# Response to Design and Landscape Comments

## 41632/APP/2025/2468 – HEATHROW FLIGHTPATH CAR PARK

TITLE: PHASE 1 - LANDSCAPE PLAN

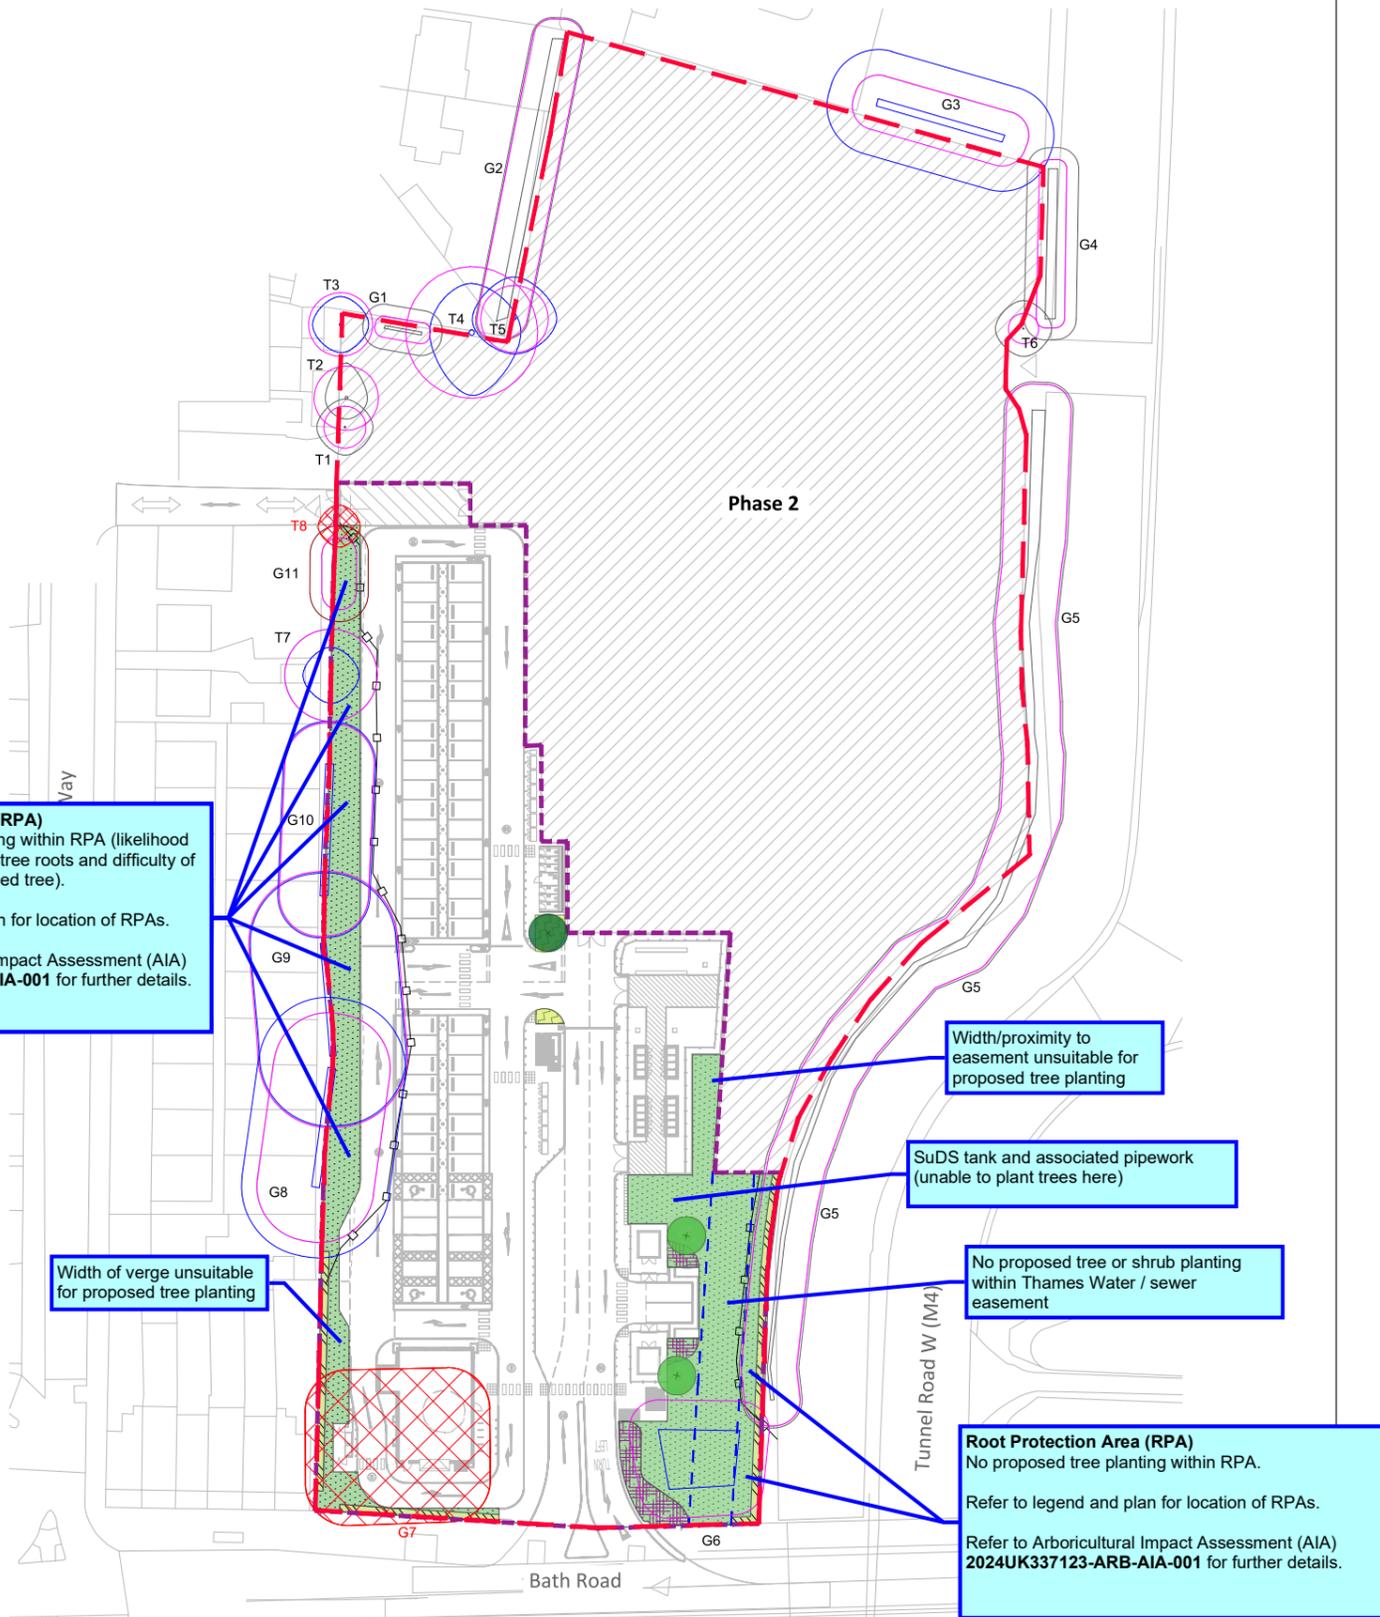
<p>Currently, there is insufficient justification for the removal of G7 and G6. While these are low category tree groups they play an important function within the townscape visually screening the car park. Additionally, it has not been demonstrated that adequate replacement tree planting has been proposed to comply with the London Plan Policy G7 Trees and Woodlands, which states:</p> <p><i>"If planning permission is granted that necessitates the removal of trees, there should be adequate replacement based on the existing value of the benefits of the trees removed, determined by, for</i></p>	<p>The removal of tree group G7 is required to facilitate the construction of the F&amp;B unit. As set out above, this is the optimum location for the F&amp;B unit from an operational perspective to attract a tenant, and will be consistent with the commercial context. The removal of tree group G6 is also required as it sits above the existing wayleave. The removal of both groups is also required from a highways perspective to allow appropriate visibility splays into and out of the Site, to allow the approved access from Bath Road to function effectively.</p> <p>Despite the loss of G6 and G7, the landscape planting proposed within the Site replaces a large area of hardstanding with a combination of hardstanding and greenspace, representing ecological and landscape betterment to the existing Site. The applicants have balanced the need for proposed tree planting against existing</p>

<p>Additionally, a boundary fence is proposed well within the root protection zones of all the boundary trees. Boundary fences should not be located close to tree trunks within Root Protection Zones (RPZs) because construction can damage roots, compact soil, and stress the tree, potentially leading to decline or instability.</p> <p>The limited space remaining around the site beyond the hedge planting is grassland with some bulb planting.</p> <p>The landscape proposals should be revised to take account of the comments above with more space dedicated to landscape to avoid the issues raised.</p>	<p>The proposed boundary fencing has been designed to ensure there will be no harmful impacts on the RPZs. The need for boundary fencing for security purposes needs to be balanced against the protection of the boundary trees in this instance, which has resulted in the proposed fencing.</p> <p>Furthermore, Appendix D of the submitted Arboricultural Impact Assessment contains guidance on the intended appointment of an Arboricultural Clerk of Works ('ACoW') for the construction stage, including the installation of new fencing within RPZs.</p> <p>Notes on fencing from within this section are as follows:</p>

Consultee Comment	Applicant Response
<p><i>example, i-Tree or CAVAT, or another appropriate valuation system."</i></p> <p>The phase 2 layouts show areas of green space that has the potential to host replacement tree planting, this needs to be included within this application to give certainty replacement trees can be accommodated on site.</p>	<p>constraints (including the wayleave, available space/suitable soft landscaping areas and existing RPZs). It is also proposed to include an area of woodland planting matrix, more standard native trees and a number of extra heavy standard proposed trees as part of Phase 2. A detailed Phase 2 Landscape Plan will be prepared as part of the submission of Reserved Matters for the rear portion of the Site, which will refine this detail.</p>
<p>Further the landscape proposals show hedge planting under the canopies of trees along the eastern boundary very close to the tree trunks.</p> <p>Planting hedges under existing tree canopies is generally unsuitable due to competition for water and nutrients, low light levels, and dry soil conditions, which hinder hedge growth. It can also damage tree roots during planting, create maintenance difficulties, and lead to poor long-term health for both the tree and hedge.</p>	<p>WSP drawing ref: 0586-WSP-XX-XX-DR-L-1011-S2-P02 contains the specific detail for how the hedges planted under the tree canopies will function. The are details produced with the intention that intrusion and potential impacts on roots will be minimised.</p> <p>The hedgerows also provide a significant contribution towards the BNG across the Site, and their removal would have a negative impact on this element of the scheme.</p>

Consultee Comment	Applicant Response
	<p><b><i>"INSTALLATION OF NEW FENCING WITHIN ROOT PROTECTION AREAS</i></b></p> <p><i>On-site walkover assessment is to be undertaken by the relevant contractor and ACoW prior to construction, to identify whether bespoke fencing is required to accommodate installation within RPAs and mitigate potential root damage.</i></p> <p><i>Excavations within RPAs shall be undertaken under the direct supervision of the appointed ACoW.</i></p> <p><i>Post holes shall be excavated manually using hand tools and lined with joined visqueen or similar impervious membrane, to prevent leaching of materials associated with installation of fence post footings.</i></p> <p><i>Post holes to be re-positioned to avoid and retain large diameter (i.e. &gt;25mm diameter) roots encountered during hand-digging of post holes."</i></p> <p>The Applicant is willing to accept a condition to ensure these measures are undertaken to prevent damage to the RPZs.</p>
